Recommendation Report for Planning Permission for Works or Extension to a Dwelling

REF NO: FP/148/21/HH

LOCATION: 120 Limmer Lane
Felpham
PO22 7LP

PROPOSAL: 2.0m single storey extension, amendments to existing window arrangements, and removal of redundant chimney stack

120 LIMMER LANE
 FELPHAM PO22 7LP
 FOR: C. Tongye
 JOB: Proposed Kitchen Extension
 TITLE: Ground Floor & Roof Plan as Proposed
 SCALE: 1:100 DATE: May 21
 DRG. NO CT-21-03

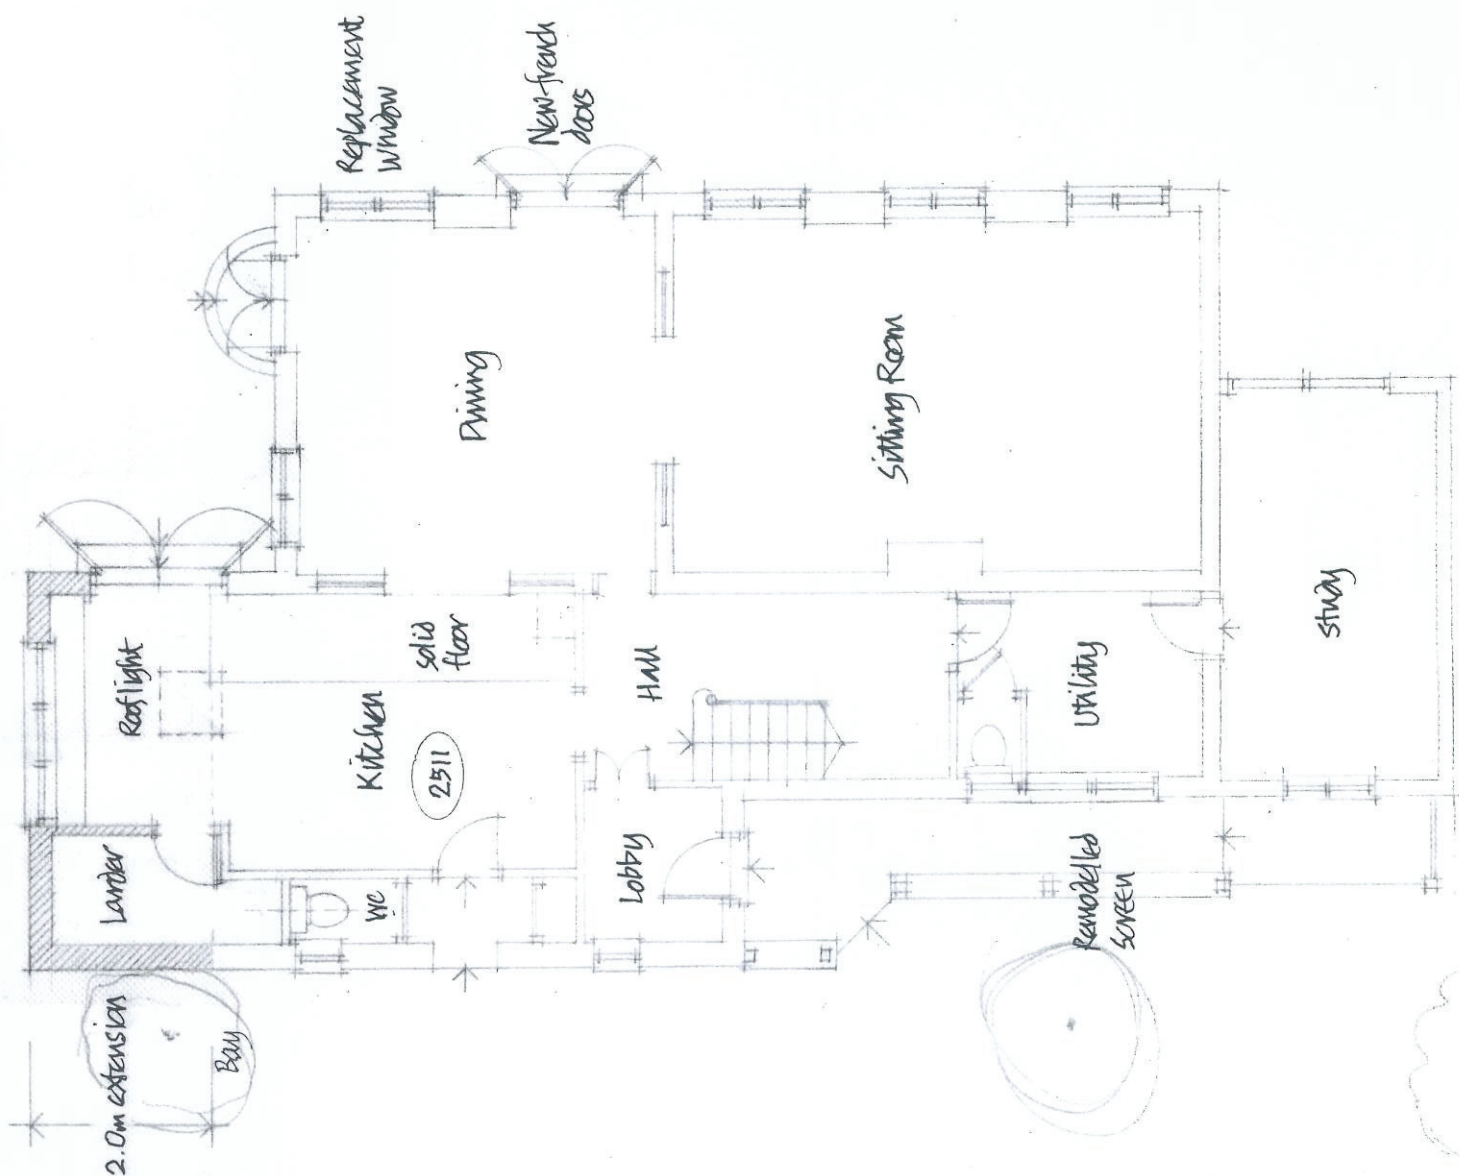
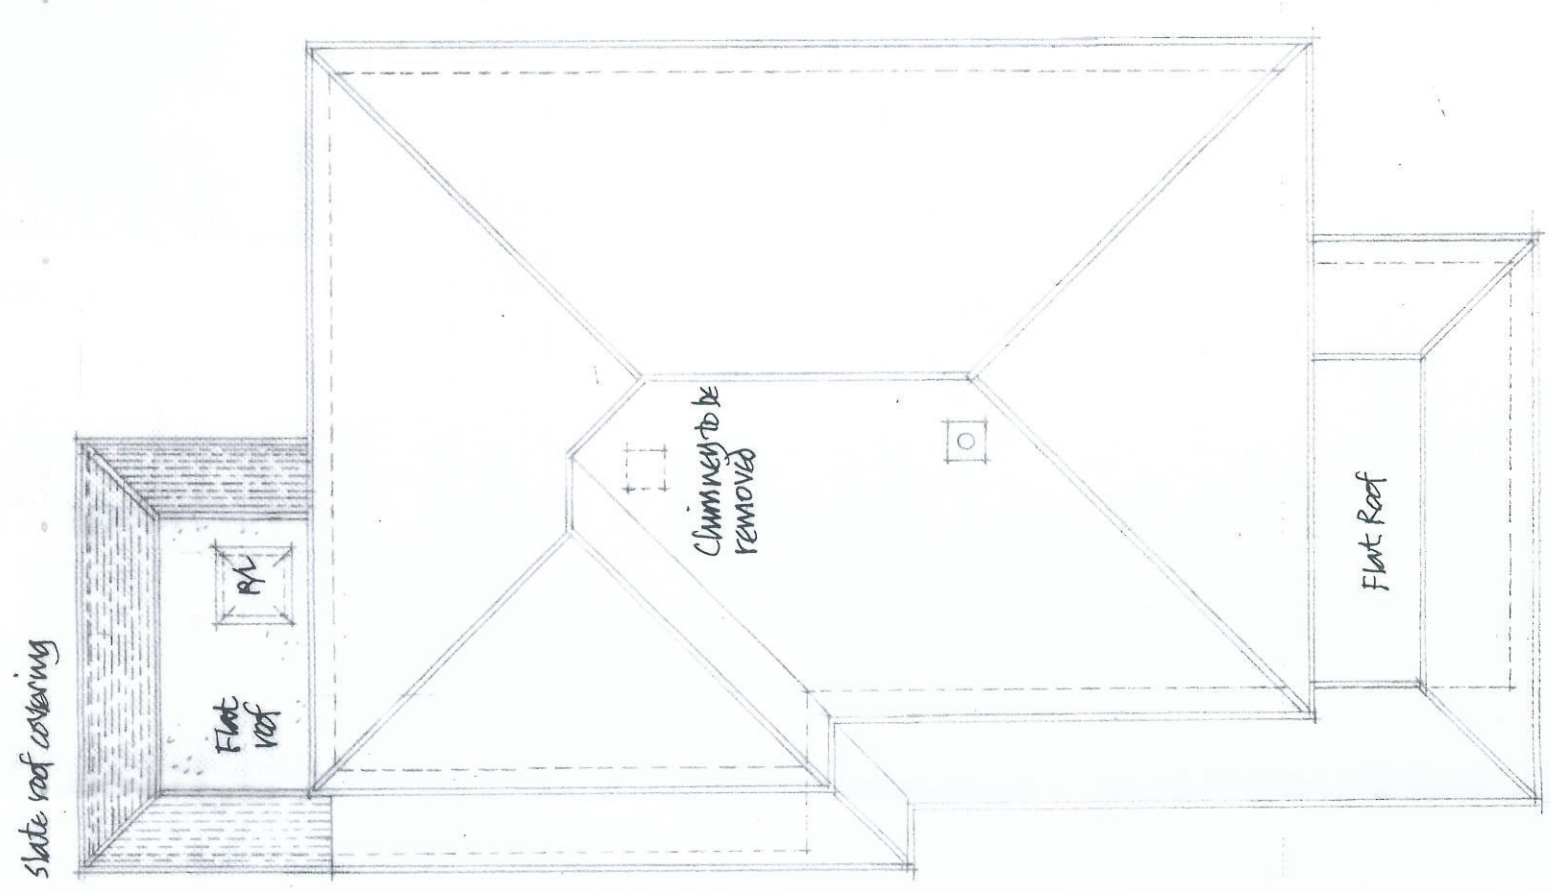
The single storey extension will be sited to the north east corner of dwelling to part infill the east principal elevation. Due to the siting to north east side it will have restricted views from the street scene and will not adversely impact character of surrounding area so complies with policy D D DM1 of the Arun Local Plan. Due to the flat roof with hipped ends design, it visually integrates with the existing dwelling roof design and being at single storey it is visually subservient to the main dwelling so complies.

The extension will have a width of approximately 5.64m and a depth of approximately 2.42m. The height to top of roof will be approximately 3.66m. There is a gap of around 16.5m remaining to east side boundary, 9.0m remaining to north side boundary and 9.0m remaining to south side boundary. There will be one new large window (3 window panes) to east elevation and one new double doors to rear (south) elevation facing garden to rear. There will also be one new roof light to centre of roof.

Arun recently adopted a Design Guide. It states development should be subservient to the main dwelling and this complies in terms of size and scale. It states that for side extensions must not close important gaps in the street scene by leading to a terracing effect, or remove existing external access from front to back gardens. This can generally be ensured by keeping extensions at least 1m away from the side boundary of a plot at ground floor. The proposal complies with this. It also states when extensions include roof lights, these should maintain the privacy of neighbouring properties. Rooflights should be used sparingly, discreetly, and centred on the roof. The roof light complies with this.

FOR: C. Tangye
JOB: Proposed Kitchen Extension
TITLE: Elevations as Proposed
SCALE: 1:100 DATE: May 21
DRG. NO. CJ. 21.04

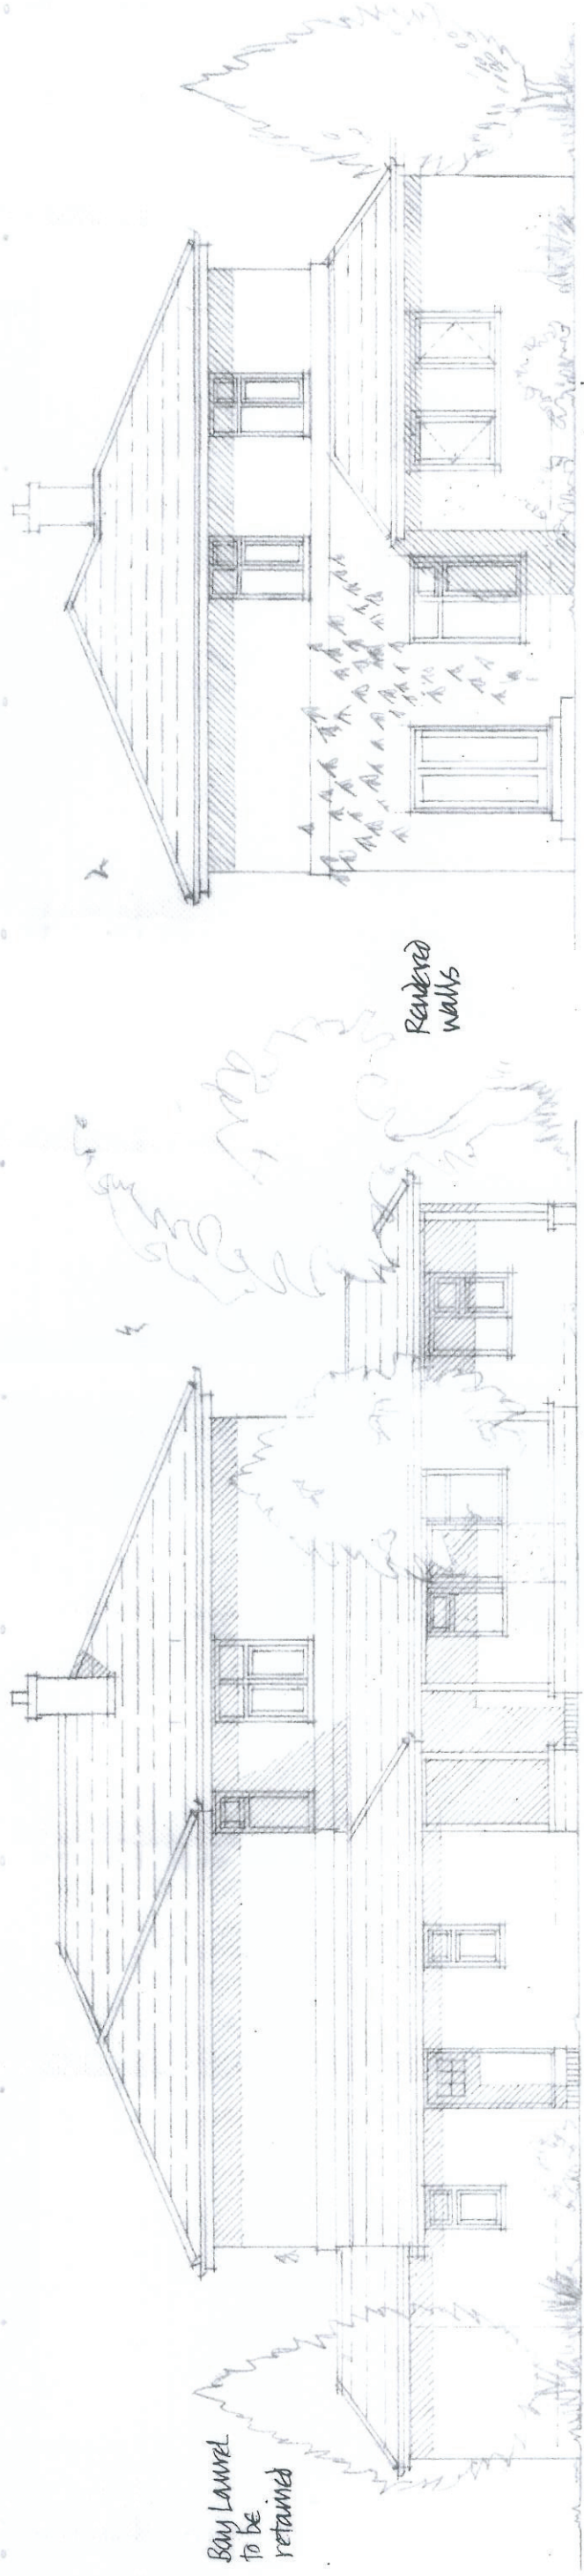
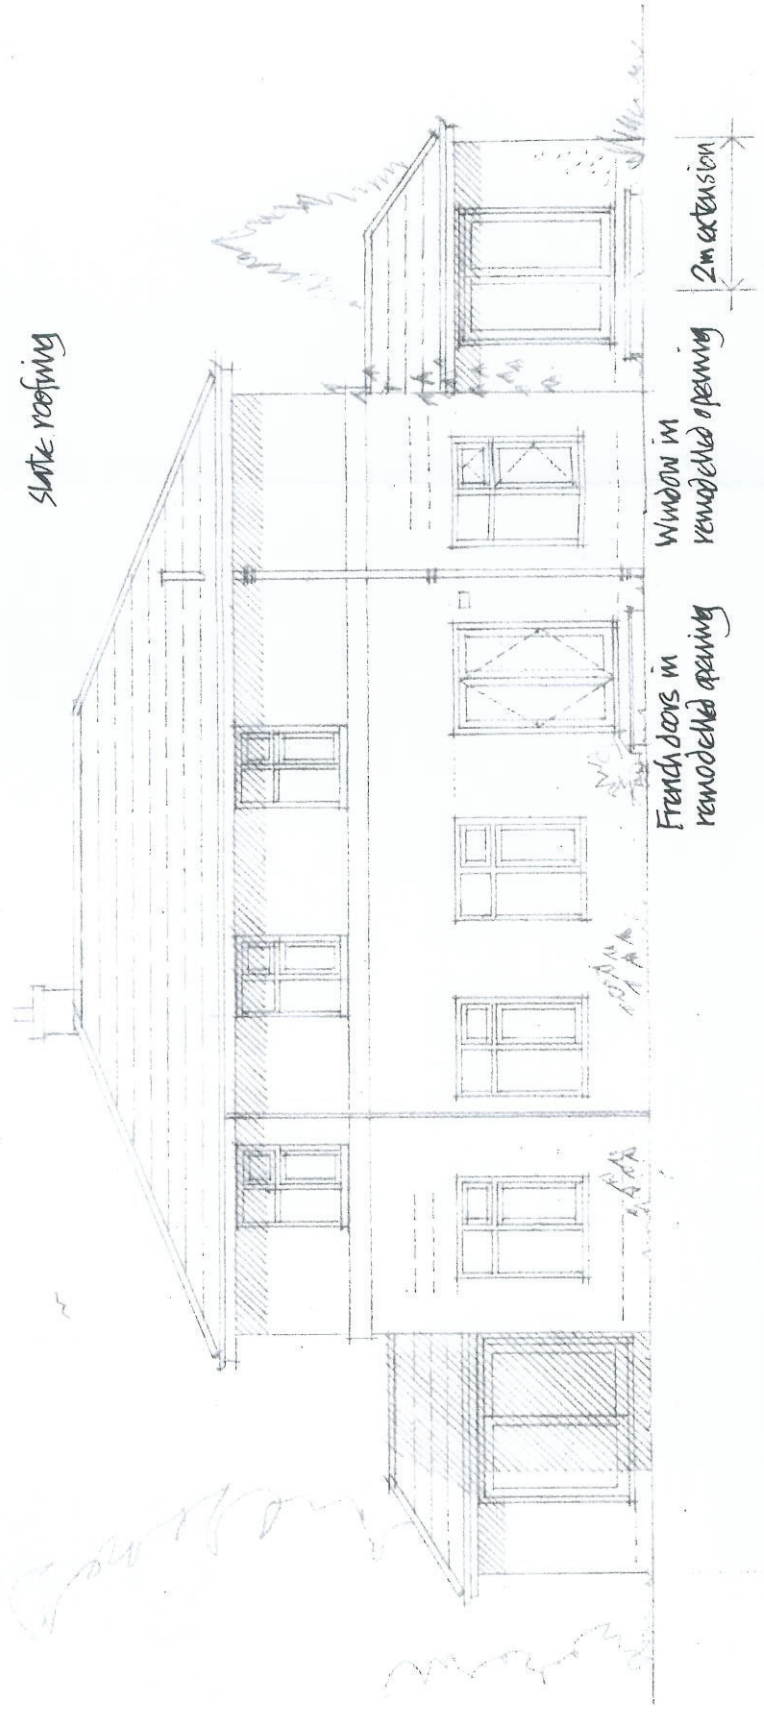
The window amendments are to the rear (south facing) windows sited at the rear principal (south) ground floor elevation. The existing two single windows will be replaced with one set of new French double doors in a remodelled opening and one new window (2 window panes) in a remodelled opening to rear (south) elevation facing garden to rear.

There are amendments to front (north) of property with the existing door opening to be blocked up to cill level and one new window will be installed to front (north) principal elevation.

Due to removing one of the chimney stacks sited to the east roof elevation it will be noticeable from street scene and will change the appearance of the site by altering the architectural rhythm of the building however it will not cause adverse harm to street scene or surrounding character of area so complies with policy D DM1 of the Arun Local Plan.

It also states for windows that the proposal has an appropriate choice of windows, compatible with the overall approach to design. The proposed windows seem to visually integrate with existing building and do no not harm surrounding character of area so will comply.

Due to the one new large window (3 window panes) to east elevation and one new double door to rear (south) elevation facing garden to rear there is increased risk to overlooking to neighbouring properties to east and south however due to being at single storey, large distance to eastern and southern boundary and mature hedging to boundary there is no increased risk to overlooking effects to neighbouring properties east or south so is acceptable.
